## Civil Engineering Statement – Response to Council RFIs

24,26 & 28 Middle Harbour Road, Lindfield

The Proponent has received feedback dated 23<sup>rd</sup> of April 2026 from Ku-ring-gai Council following the submission of the Xavier Knight's civil engineering documentation as part of the EIS submission for the SSD (SSD-82548708).

Scale at A1	Drawn	Approved
1:200	AH	FC
Job No	Drawing No	Revision
250213	C03003	1

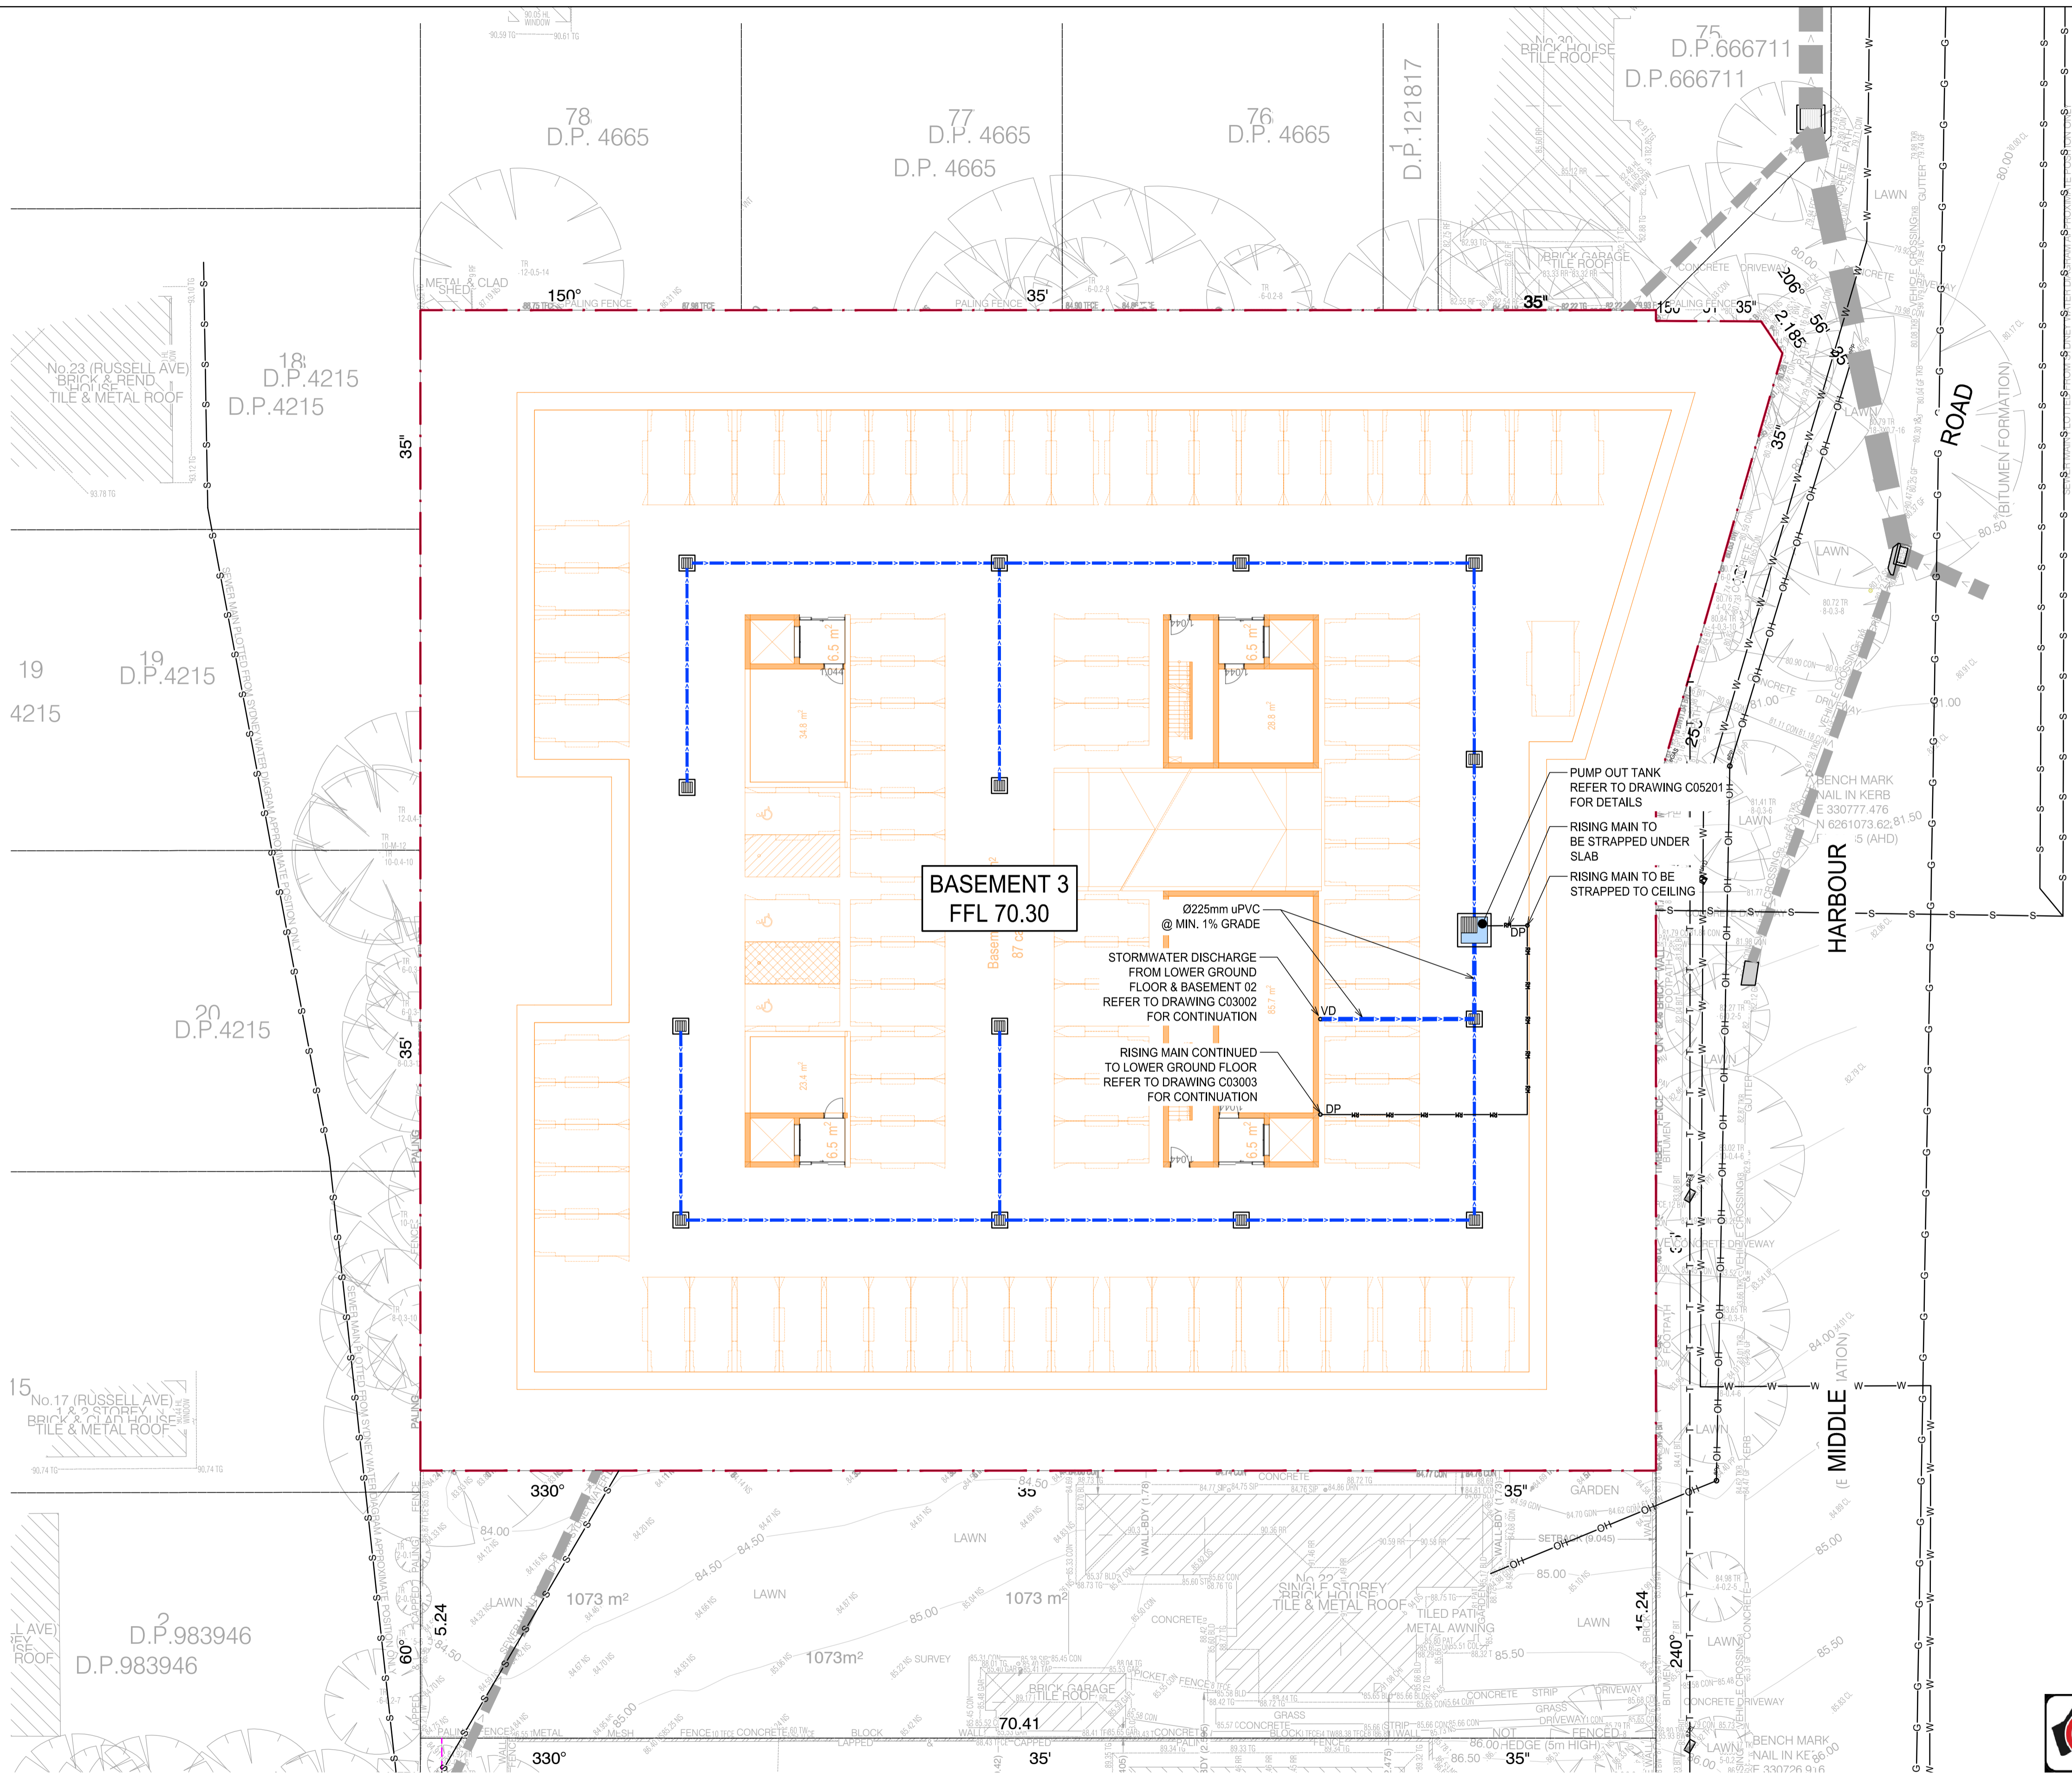
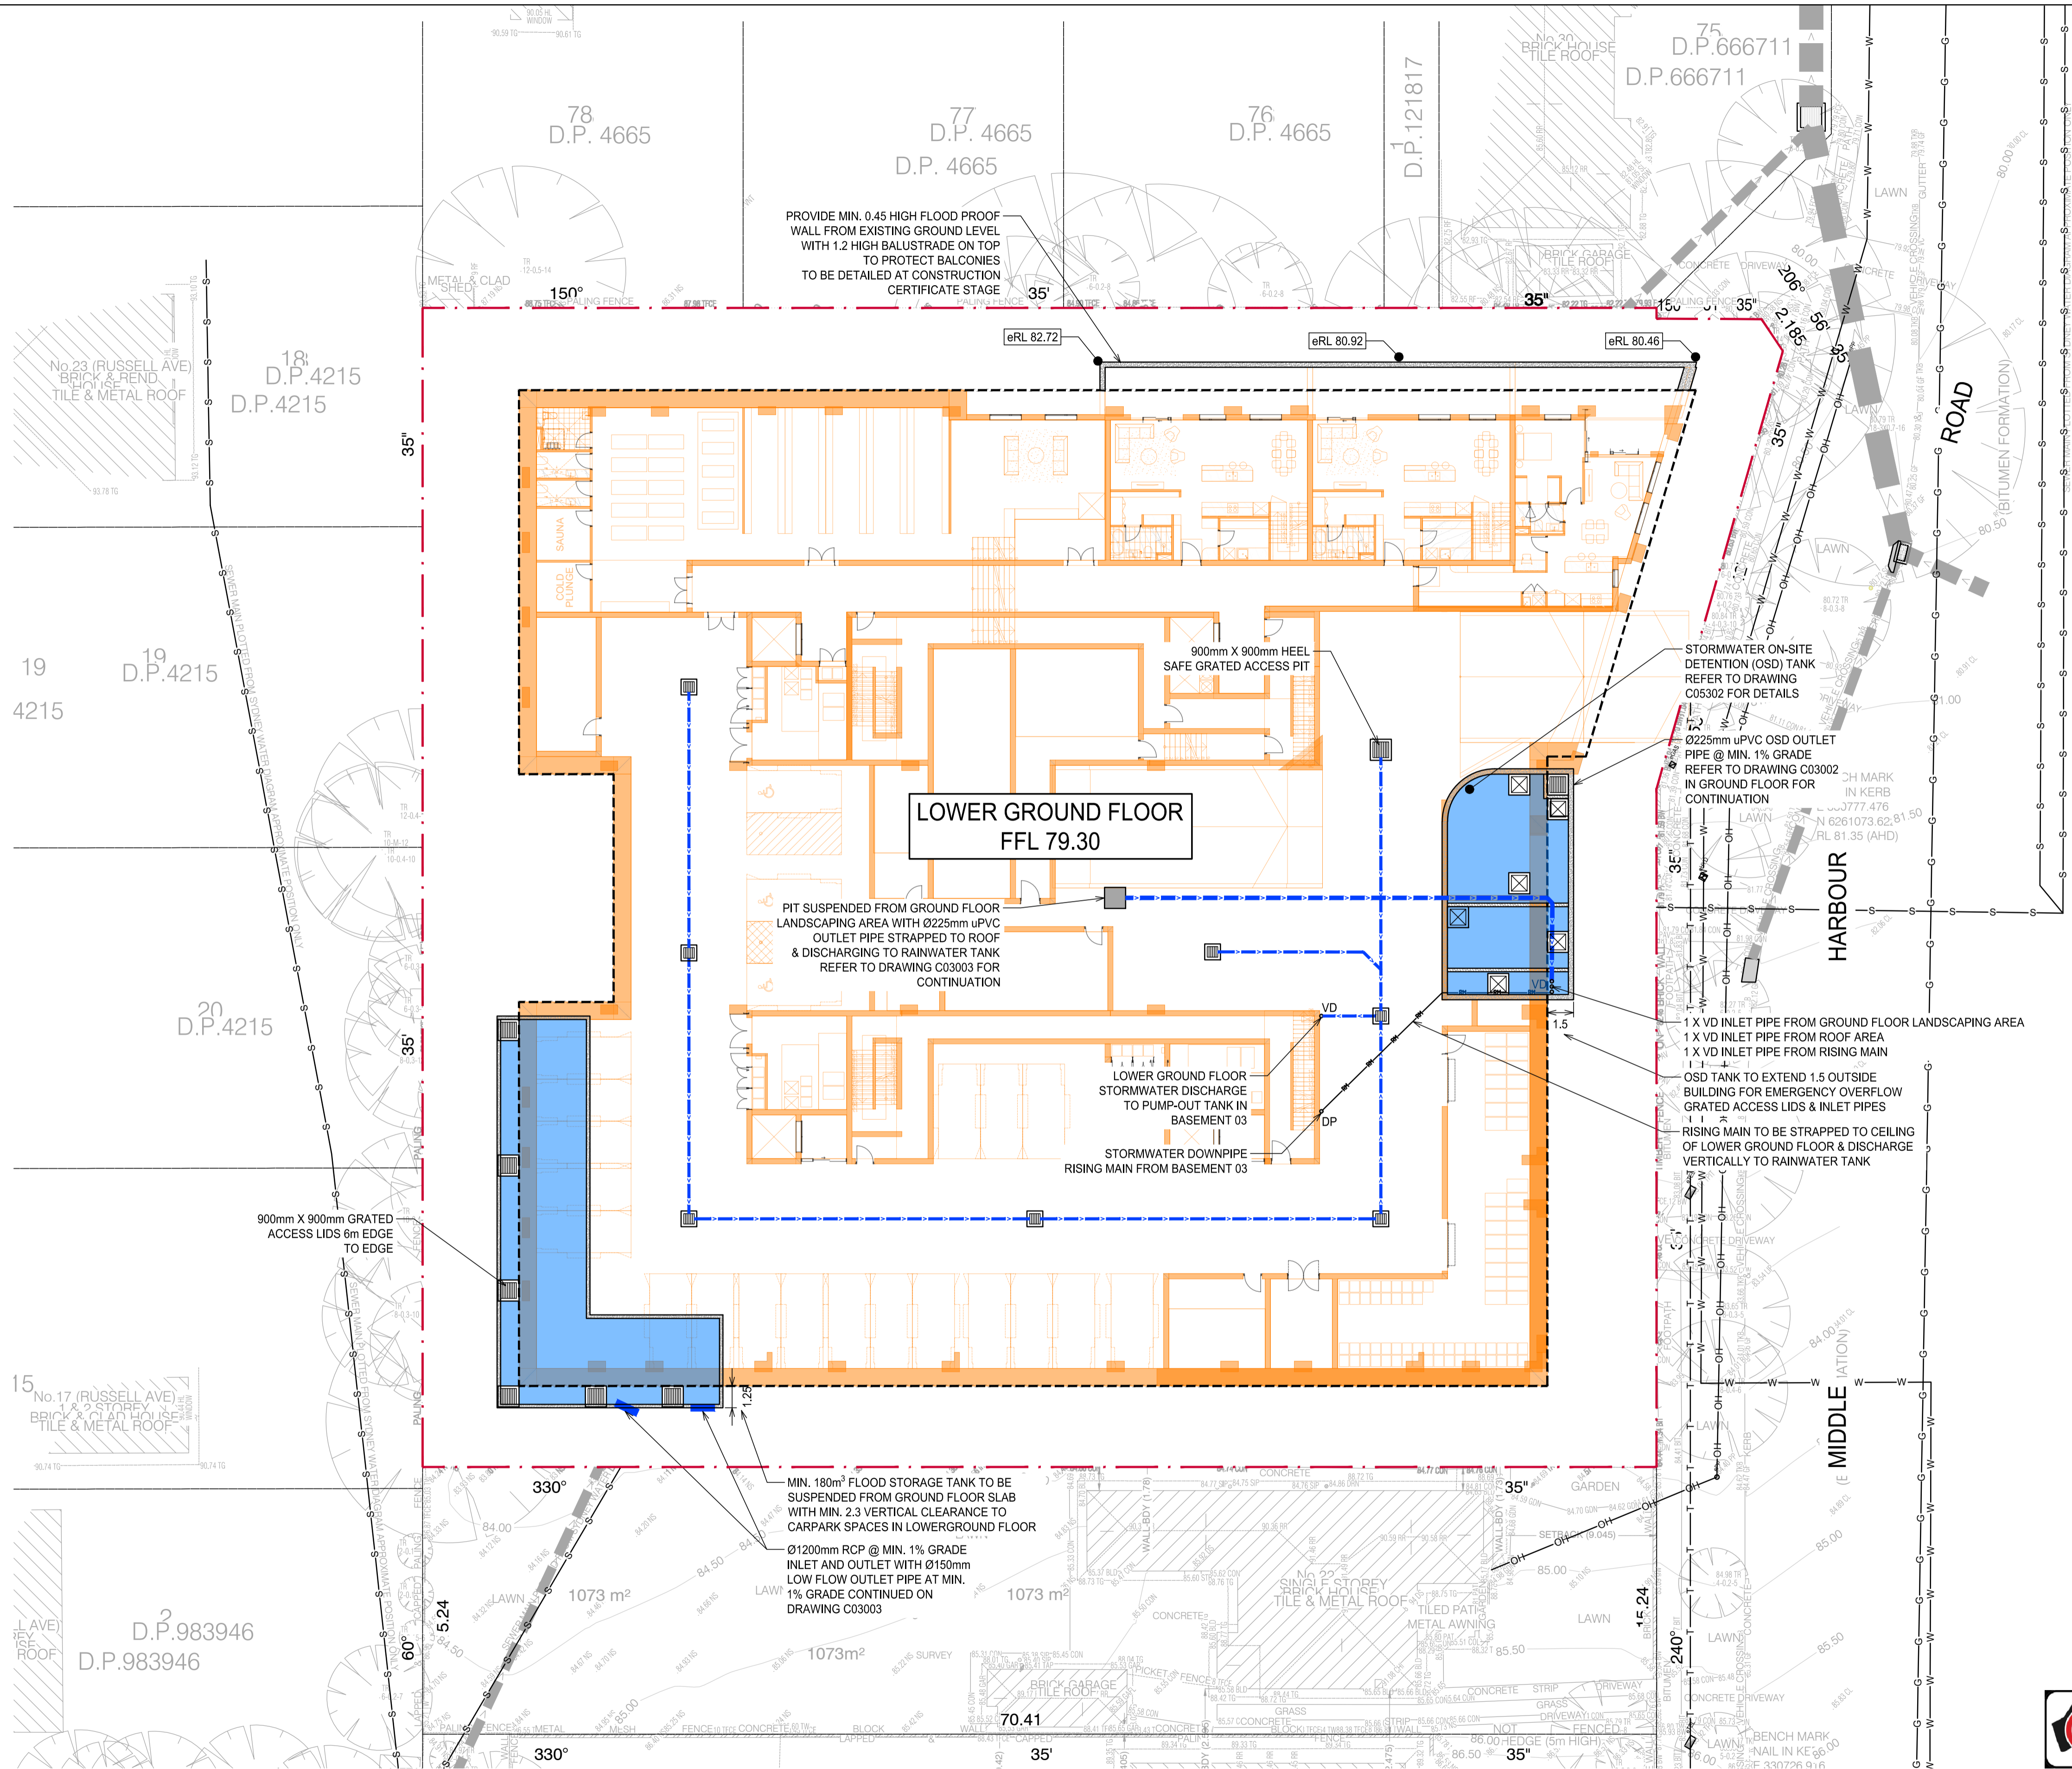
No.	Key Assessment Issue	Response
<b>Civil Plans</b>		
1	Approval from Council's Engineers within the Operations Department is required for the realign/divert Council's existing pit and pipe system. At this stage there is no approval for the works to discharge stormwater and/or realign Council's trunk drainage system.  - The submitted plans do not identify the location or extent of the proposed drainage easement, only the proposed pipeline alignment. (Not Resolved)	Refer to <b>Appendix A</b> of this statement for revised civil engineering plan C03003 showing the extent of a 2.2m wide dedicated easement over the proposed drainage diversion. The width of the easement has been determined in accordance with KDCP Part 24R.2.
2	Council's Operations Team have advised that the proposed trunk drainage diversion/re-alignment cannot be supported given that this design has several deviancies which is considered unacceptable and non-compliant.  Council's Operations Team has previously advised that the proposed trunk drainage diversion/realignment is not supported due to multiple design deviations. (Not resolved)  <u>Key outstanding issues include:</u>	Refer to <b>Appendix A</b> of this statement for revised civil engineering plan C03003 showing 90 degree bends have been replaced with 2 x 45 degree changes in directions.  Refer to <b>Appendix A</b> of this statement for revised civil engineering plan C03003 showing the extent of a 2.2m wide dedicated easement over the proposed drainage diversion. The width of the

No.	Key Assessment Issue	Response
	<ul style="list-style-type: none"> <li>- In the proposal, 90-degree system direction change was proposed. Council does not endorse this type of design. Modification is required to the 90-degree pits.</li> <li>- No details of easement over the proposed drainage system. The width of the easement shall be depicted in accordance with Part 24R.2 of the KDCP.</li> <li>- It is unclear the distance between the proposed building and drainage system. Council requires the proposed building will not be located within "zone of influence" of Council drainage system.</li> <li>- The data provide in "Integrated Water Management Plan" (page 39) "pit 1.4 floods", which indicate that the system could not convey 5% storm event. The detailed calculation is required.</li> <li>- The connections between OSD and Trunk drainage system in the proposal was not clear. Does the OSD have a 1200 mm pipe connection with 1200 mm trunk drainage? Clarification is sought.</li> </ul>	<p>easement has been determined in accordance with KDCP Part 24R.2.</p> <p>Refer to <b>Appendix A</b> of this statement for revised civil engineering plan C03003 which marks the proposed offset from the site boundary and building line. As the shoring wall will transfer building loads into the underlying bedrock, the shoring system will not impose any load on the proposed stormwater arrangement.</p> <p>This is a misinterpretation of the DRAINS data table in Appendix B of the Integrated Water Management Report dated 04.03.2026. For the row with Pit 1.4 information, the label 'FLOOD.S' refers to the connecting modelling node for the 'Flood Storage Tank' which forms part of the 1% AEP stormwater management system. Columns 30 and 31 of the results table show that for Pit 1.4 the peak water levels for the 5% and 1% AEP events are RL81.83 and RL82.25 respectively. These levels are lower than the proposed pit grate level of RL82.92. As such no flooding or surcharging occurs at Pit 1.4</p> <p>Refer to <b>Appendix A</b> of this statement for revised civil engineering plan C03003 showing the 300mm diameter connection from the OSD outlet to the proposed diversion pipe.</p>

3	<p>The proposal seeks to discharge the stormwater runoff created by the new development into Council's existing trunk drainage system which is located within the site. This trunk drainage system traverses diagonally through the property. The applicant has indicated that they wish to realign/divert Council's existing pit and pipe system to cater for the proposal. This cannot be supported in its current format as it is a major burden to Council's infrastructure and long-term</p>	<p>Refer to CCTV footage dated 04.06.2025 of the existing stormwater assets. The footage shows the section traversing the proposed development site is heavily impacted by accumulation of silts, debris and damage from tree roots. The 1200mm pipe size has been selected as it is able to cater for the combined upstream flows from the 450mm and 525mm pipes, while also providing improved capacity to remove runoff</p>

No.	Key Assessment Issue	Response
	<p data-bbox="544 394 1023 454">maintenance, ongoing system failure, deficient pipe sizing etc of the trunk drainage system.</p> <ul data-bbox="544 495 1023 853" style="list-style-type: none"> <li data-bbox="544 495 1023 752">- The applicant proposes increasing the pipe size from 900 mm to 1200 mm. However, the upstream inflows comprise 525 mm and 450 mm pipes, with the downstream connection reverting to a 900 mm pipe. According to the response the downstream and upstream pipe is in good condition, but no supporting reports or any CCTV videos has been provided.</li> <li data-bbox="544 792 1023 853">- No longsections for the drainage drawings have been submitted.</li> </ul>	<p data-bbox="1054 394 1463 454">from the surface which now be instead conveyed by the underground system. Our DRAINS model is able to demonstrate that the connection between the 1200mm pipe and the existing 900mm pipe does not result in any additional ponding or surcharging at the point of connection and there is no impact to upstream or downstream hydraulic performance during the 5% and 1% AEP storm events.</p> <p data-bbox="1054 792 1463 1021">Longitudinal sections with Hydraulic Grade Line analysis have been provided in Section 3.8 of the Integrated Water Management Plan report. A detailed longitudinal section will be prepared as part of the Design Development phase of the project.</p>
